RE: MP 09_0146 MOD 1 – EAST LAKES SHOPPING CENTRE

Thank you for your letter received 8 August 2017 regarding the proposed modification to the Eastlakes Shopping Centre, Eastlakes (DPE Ref: MP 09_0146 MOD 1).

Clare Harley
Manager Strategic Planning

5 PLAN 8th Floor  
1:100

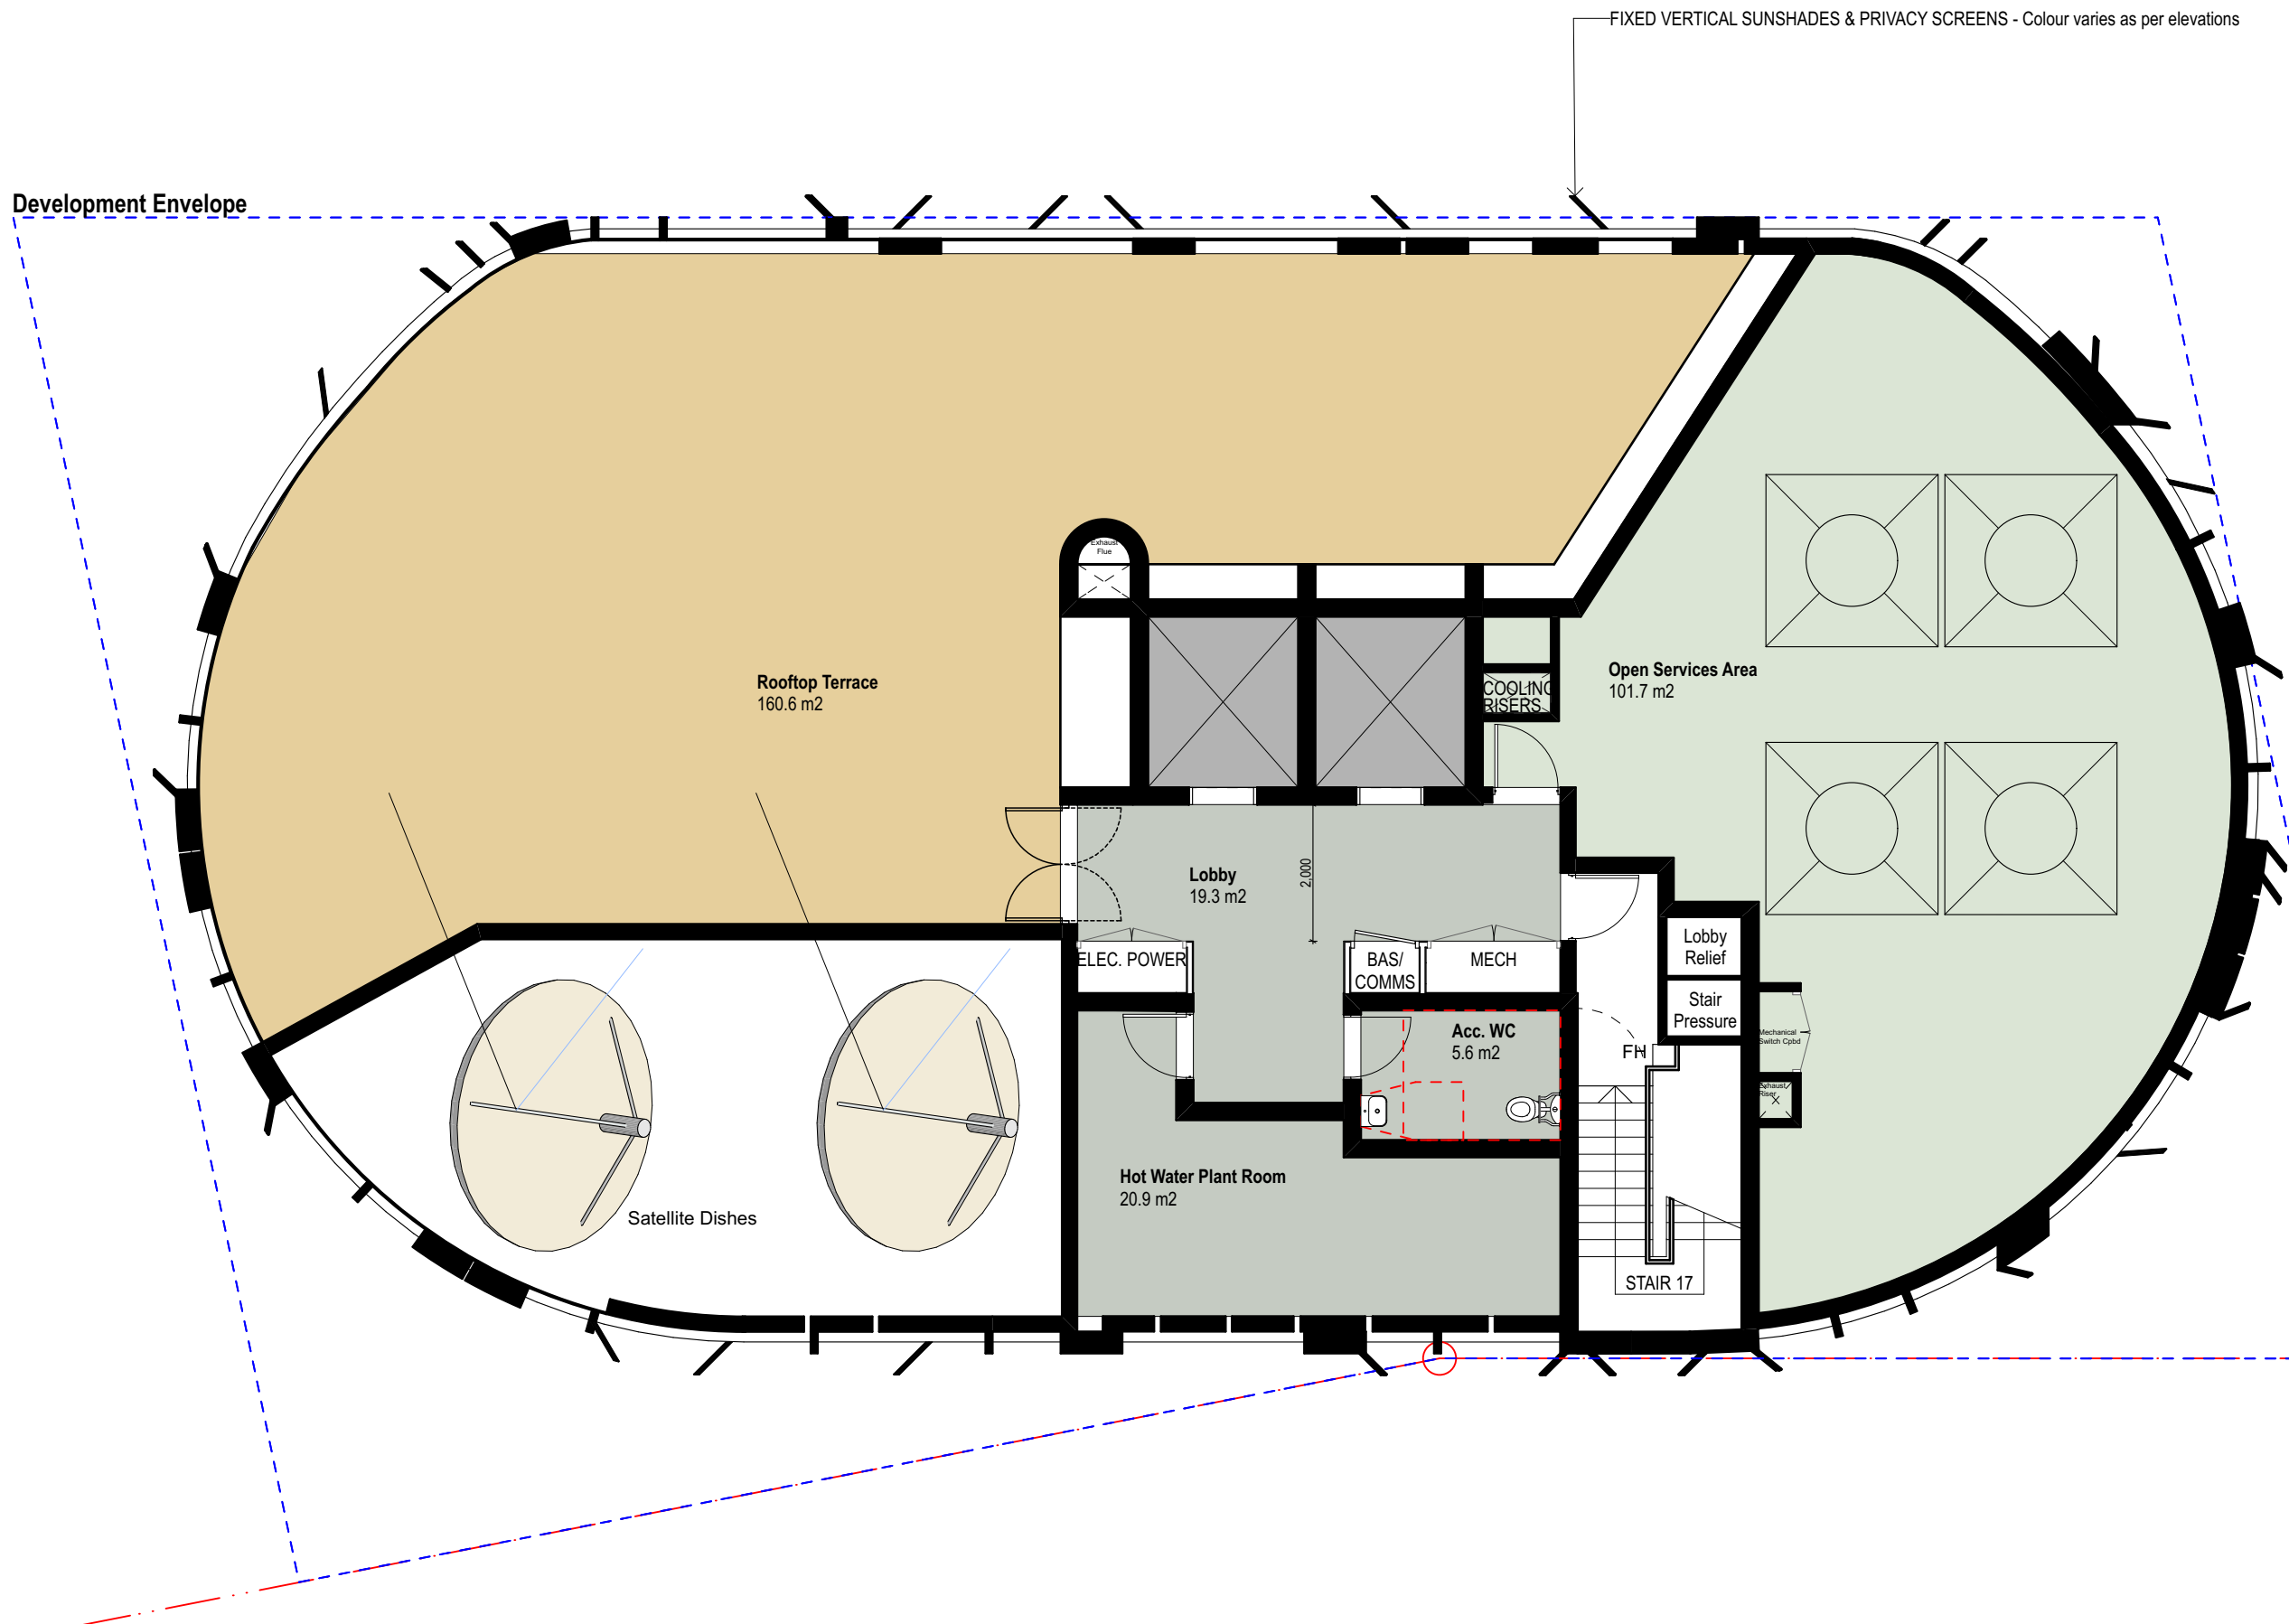
It is noted that the proposed modification to Building B1 would result in non-compliance with the building separation distance required by the Apartment Design Guide (ADG). Consideration should be given to either a revised building design to achieve compliance; or the inclusion of adequate mitigation measures in the design to ensure that the amenity of adjoining residential development is not unreasonably impacted.

All 3-bedroom apartments in Building B1 are to demonstrate compliance with *Part 4C.4.2 - Family Friendly Apartment Buildings* of the Botany Bay Development Control Plan 2013 (BBDCP 2013).

Shadow analysis 21 June - 9am

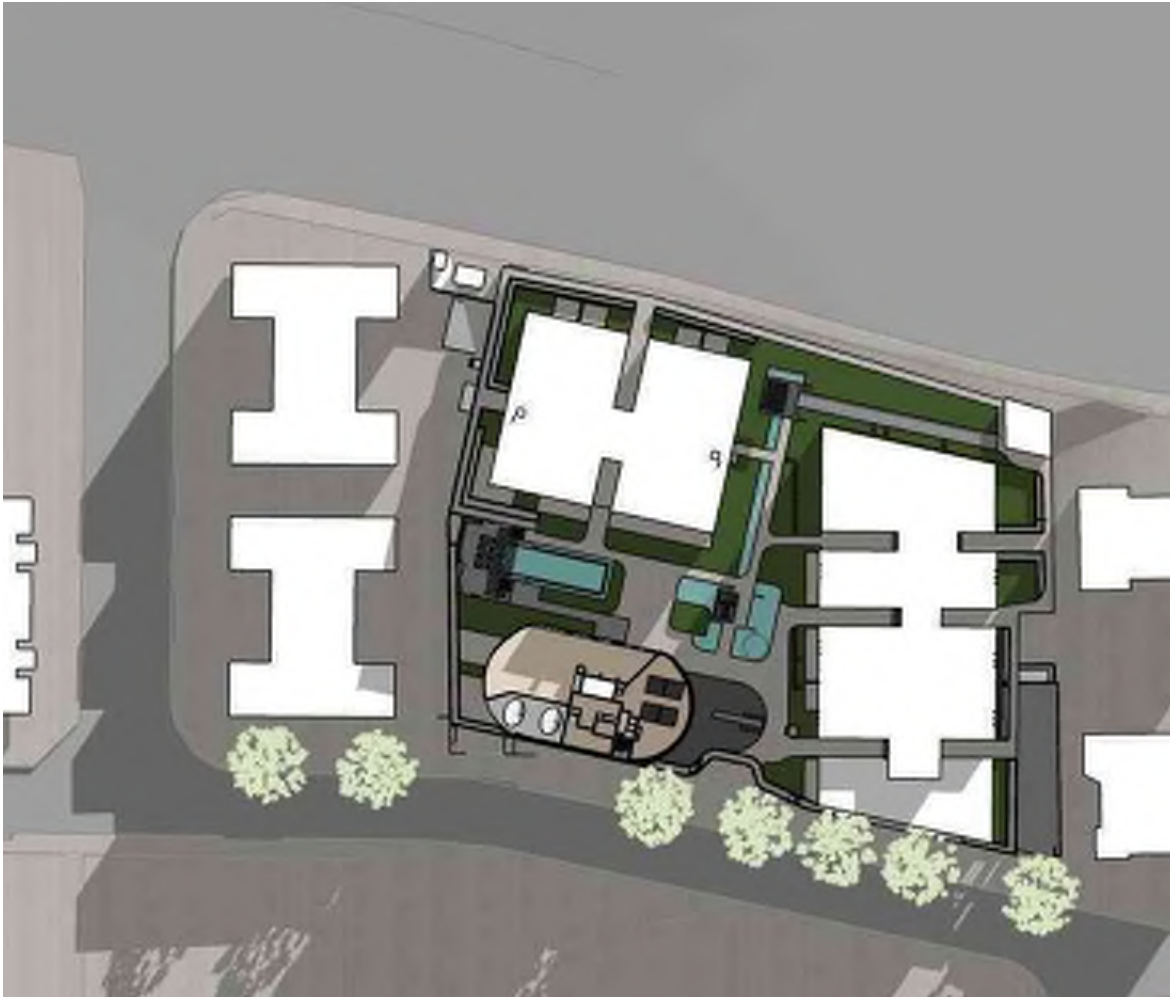
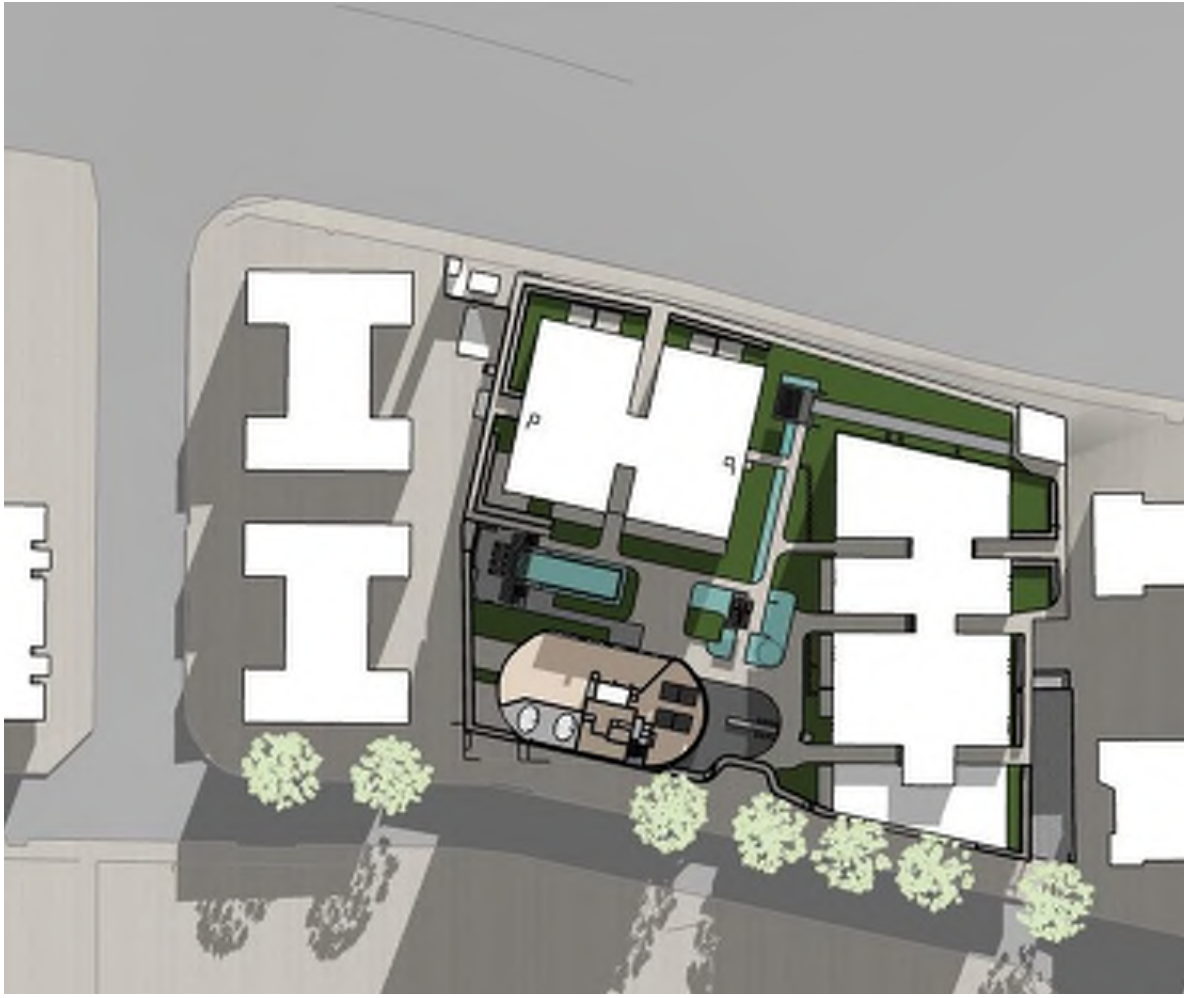
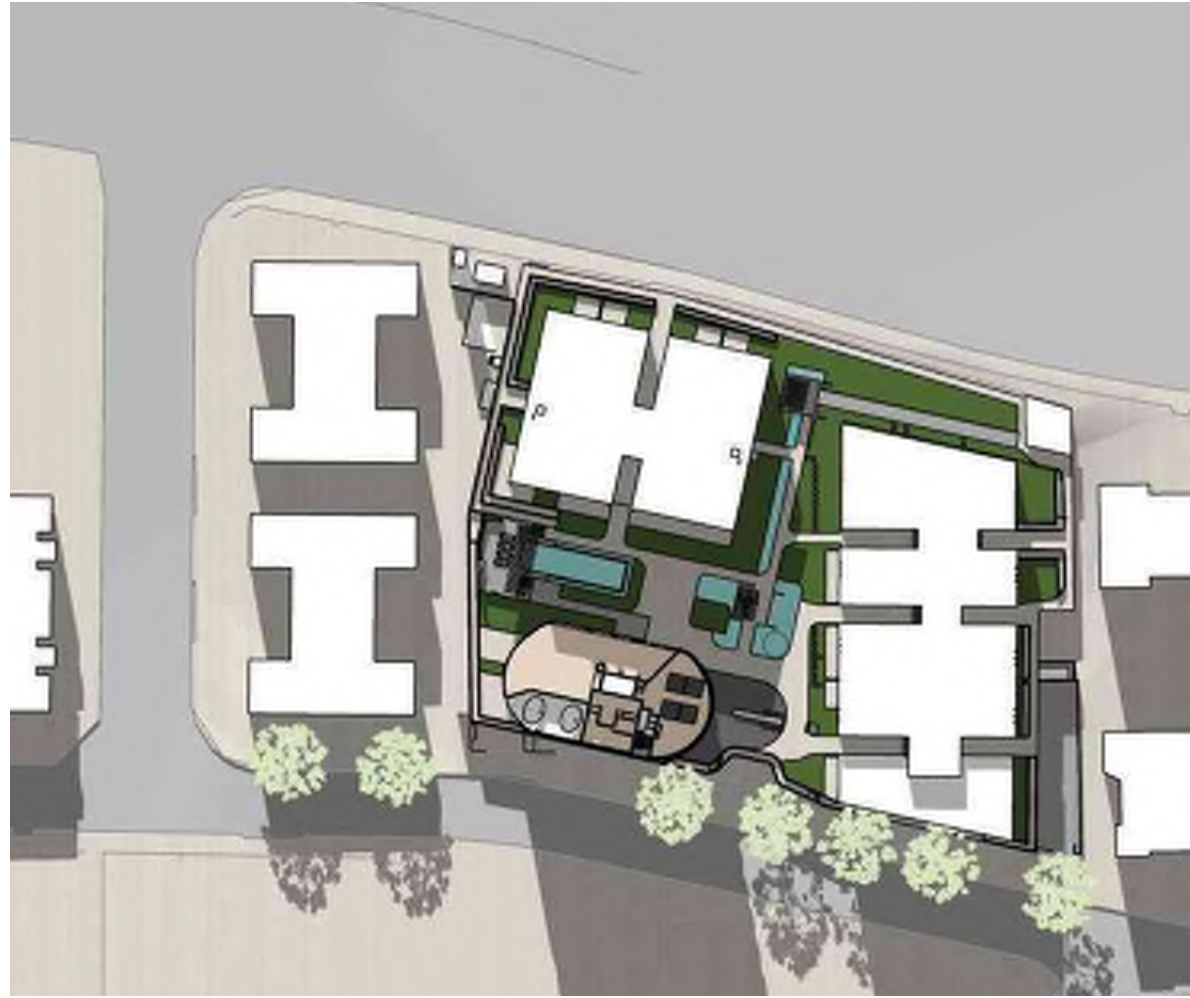
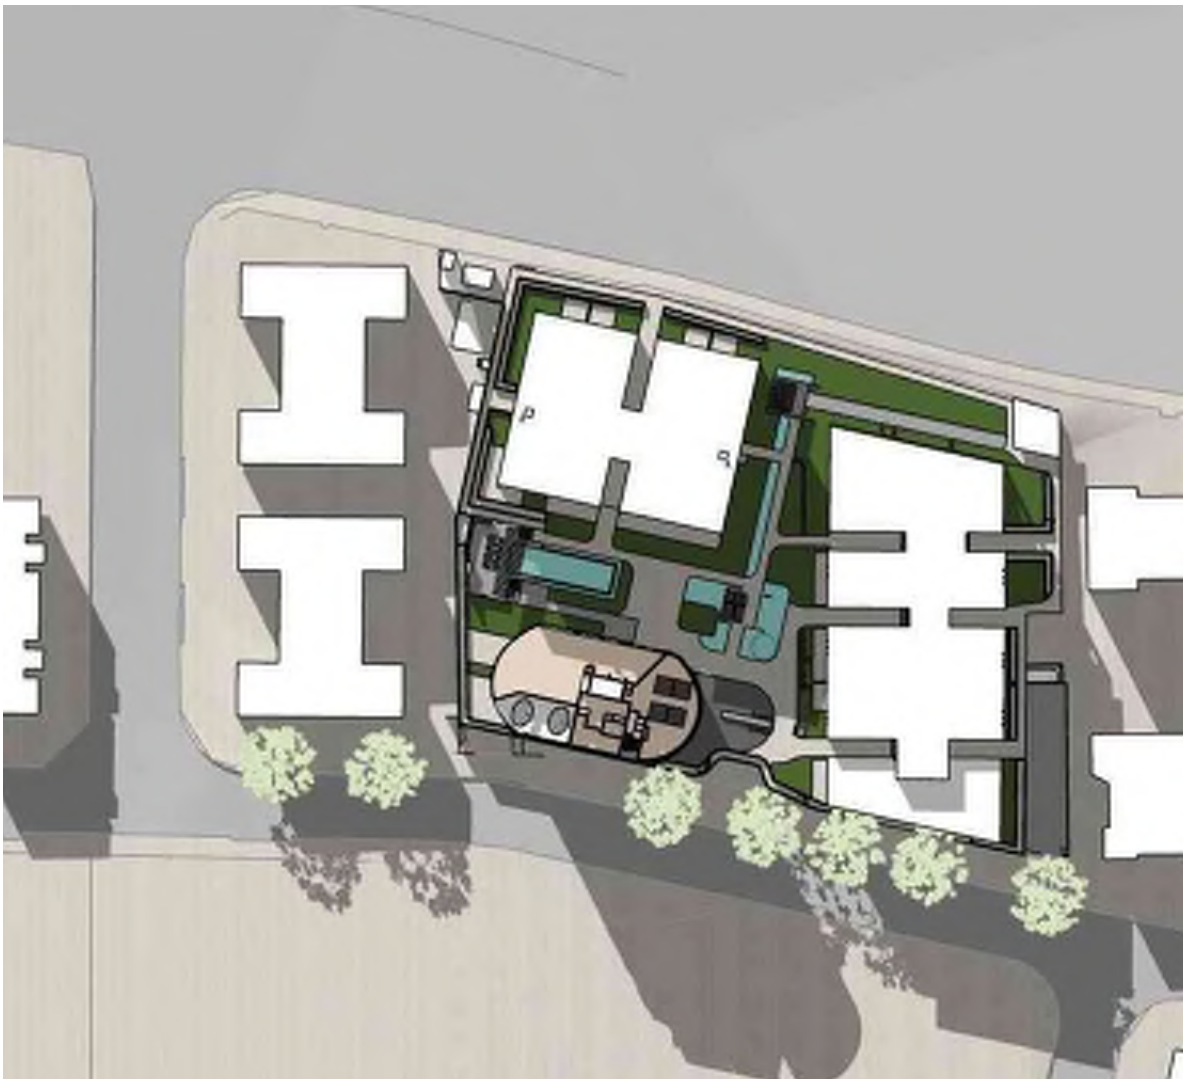
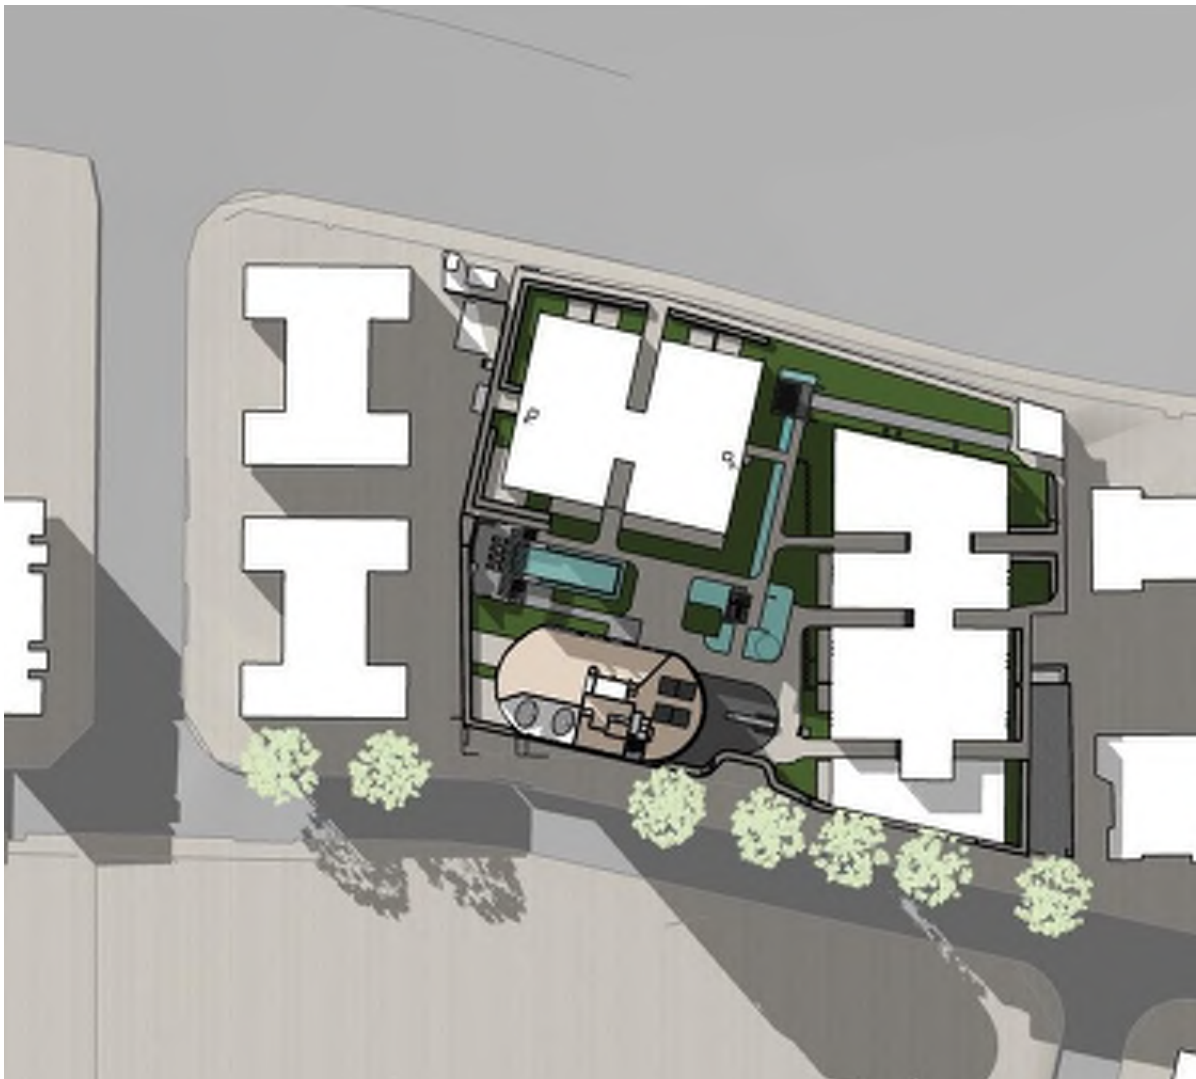
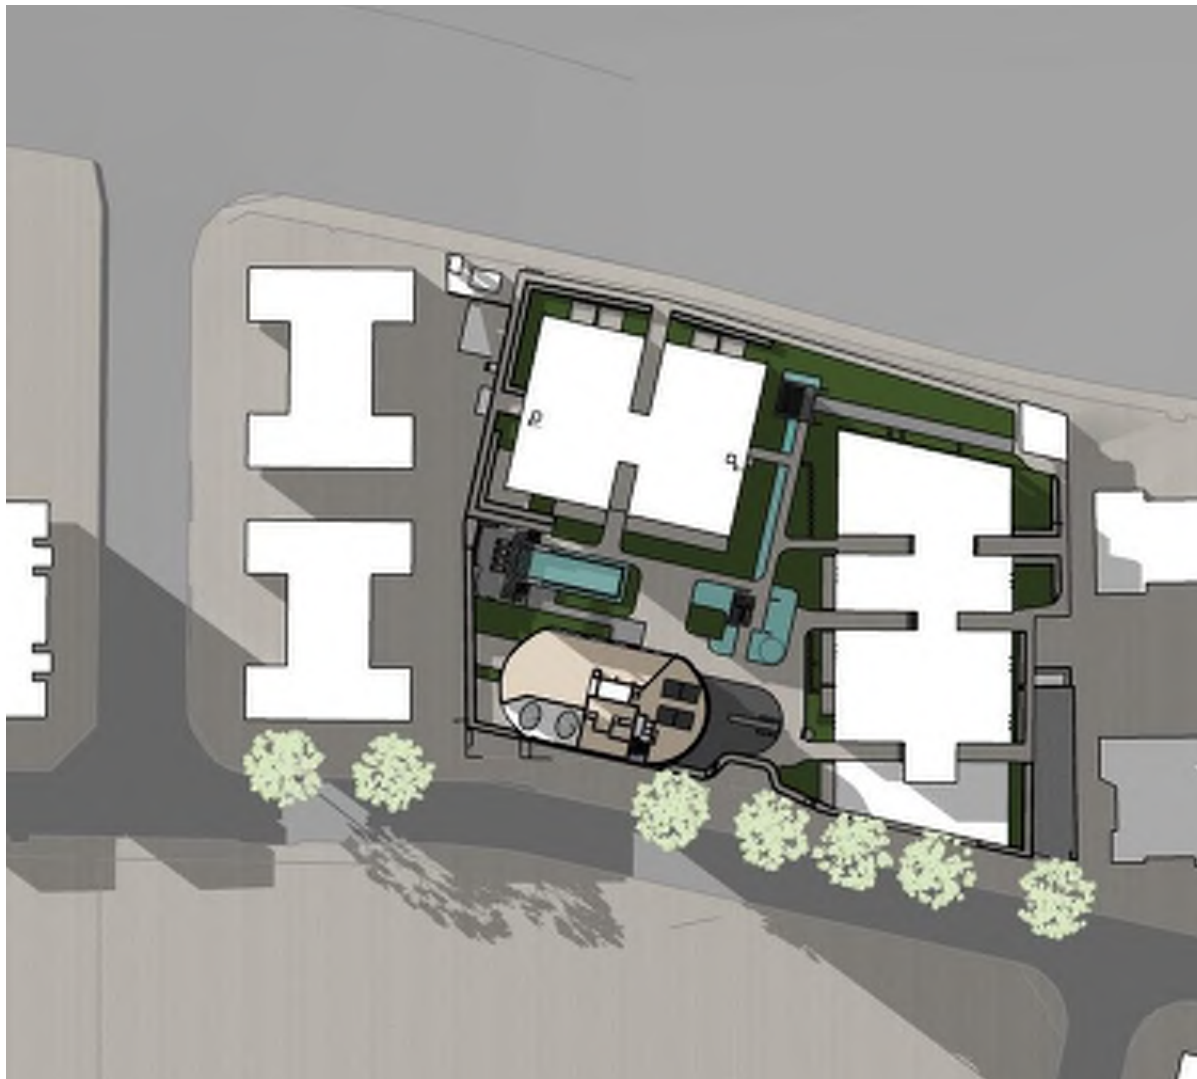
The proposed changes in height will have a significant impact on the amenity of Evans Avenue. An Active Street Frontage applies to Evans Avenue under the Botany Bay Local Environmental Plan 2013. The potential for an active street frontage along Evans Avenue will be compromised when this area is overshadowed for most of the day during winter. Reference is made to the overshadowing diagrams (Sheet no S75W 130012) which indicate that both the Northern and Southern sides of Evans Avenue will be overshadowed for most of the day during winter.
